Recommendation Report for Planning Permission for Works or Extension to a Dwelling

REF NO: LY/14/25/HH

LOCATION: Ubuntu
Priory Farm
Station Road
Arundel
BN18 9PH

PROPOSAL: Single storey extension.

ROOF PLAN

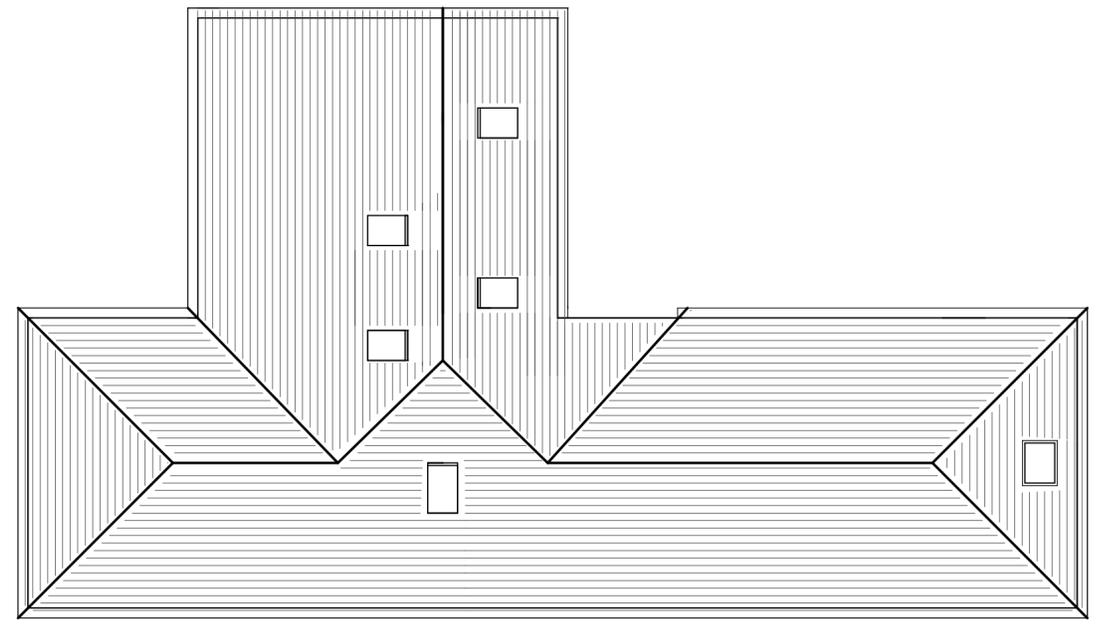
The proposal is for a modest single storey extension which, in principle, appears acceptable in this location. Its siting and scale ensure that it remains subservient to the host building, and the intention to use a lightweight structure with generous glazing is appropriate in concept. However, the detailed design raises concerns. The proposed rooflights are disproportionately large, and the use of uPVC windows and doors is not supported. Standard modern rooflights are also unsuitable. Windows and doors should be timber, and any rooflights must be of a heritage type set flush with the roof slope to minimise visual impact.

The extension would square-off the rear of the property, extending 6m towards the north western flank and 3.3m towards the rear (south western) elevation, in line with the guidance set out in the Arun Design Guide (ADG). The roof would be hipped, have a ridge height of 3.35m and would incorporate four roof lights (of a heritage type, set flush with the roof slope), two on both the south west and north east roof slopes. The extension would be open and lightweight in character, with generous glazing, appropriate for its location and purpose. The extension would be a subservient addition, in accordance with Arun Local Plan policies D DM1 and D DM4.

- 3 The rooflights within the roof slopes of the extension hereby approved shall be of a heritage type, set flush with the roof slopes.

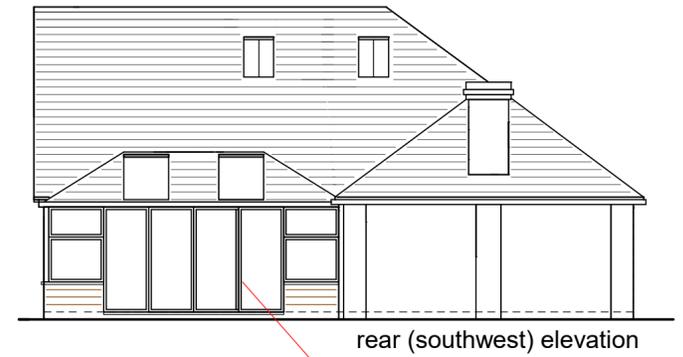
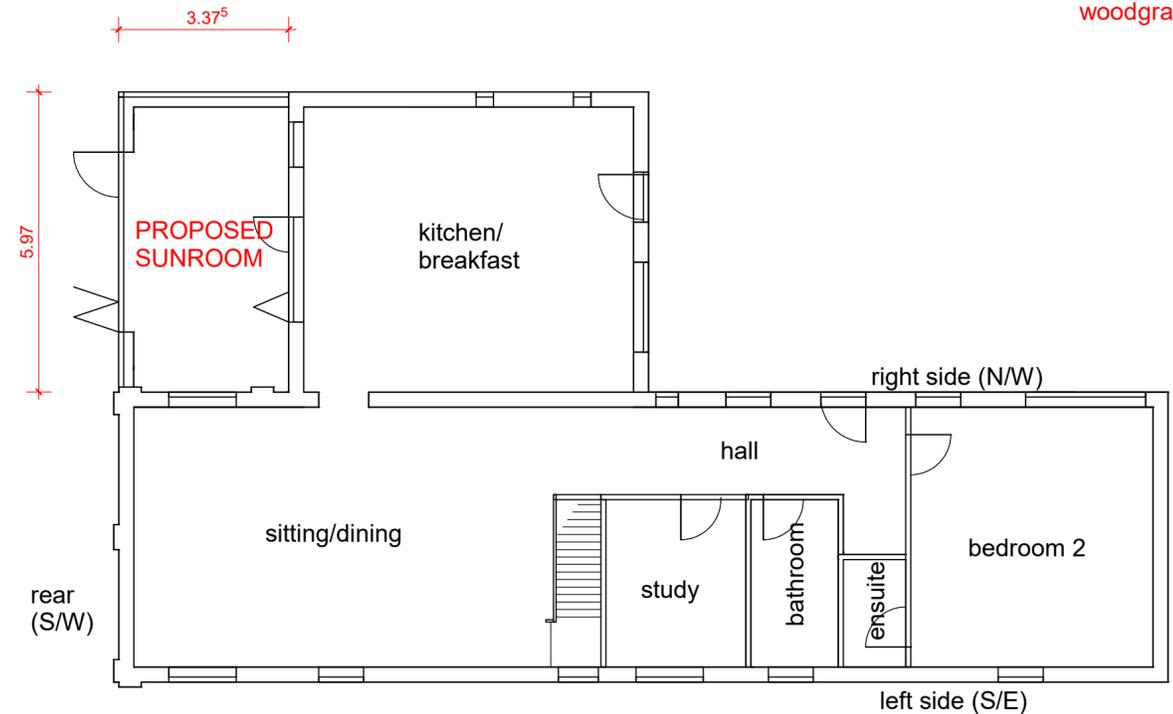
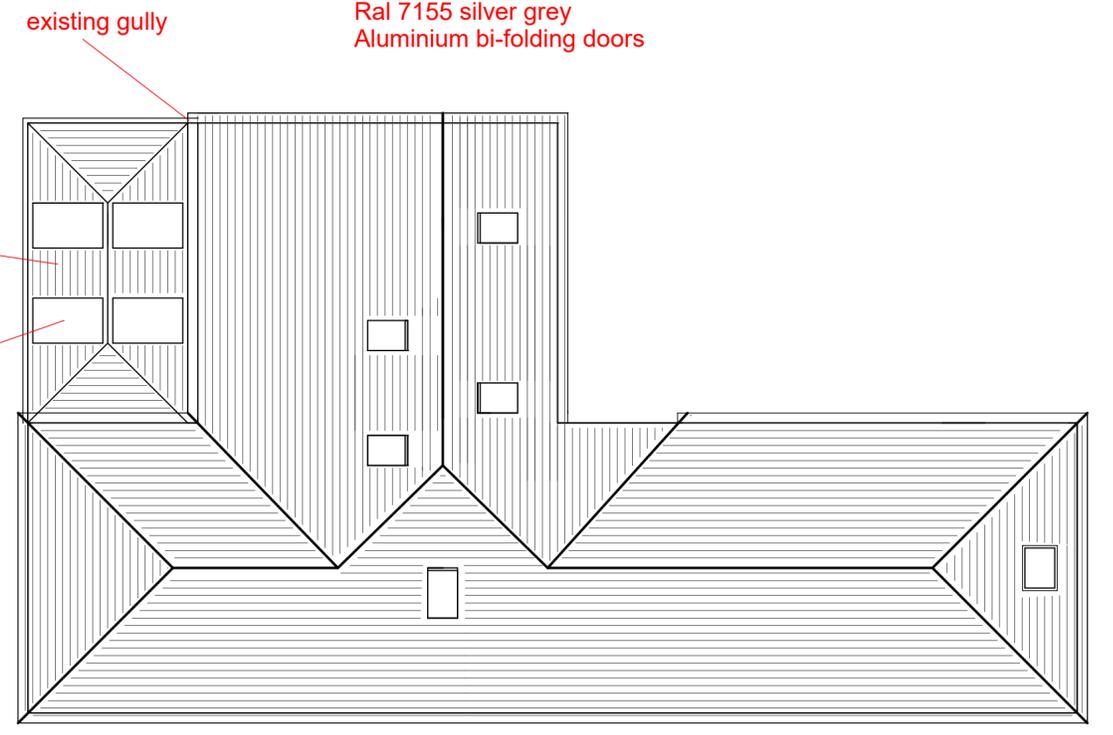
Overall, while the principle of a modest single storey extension is supported, the current detailing is problematic. The scheme should be revised to ensure the extension preserves the character of the building and achieves the least possible impact.
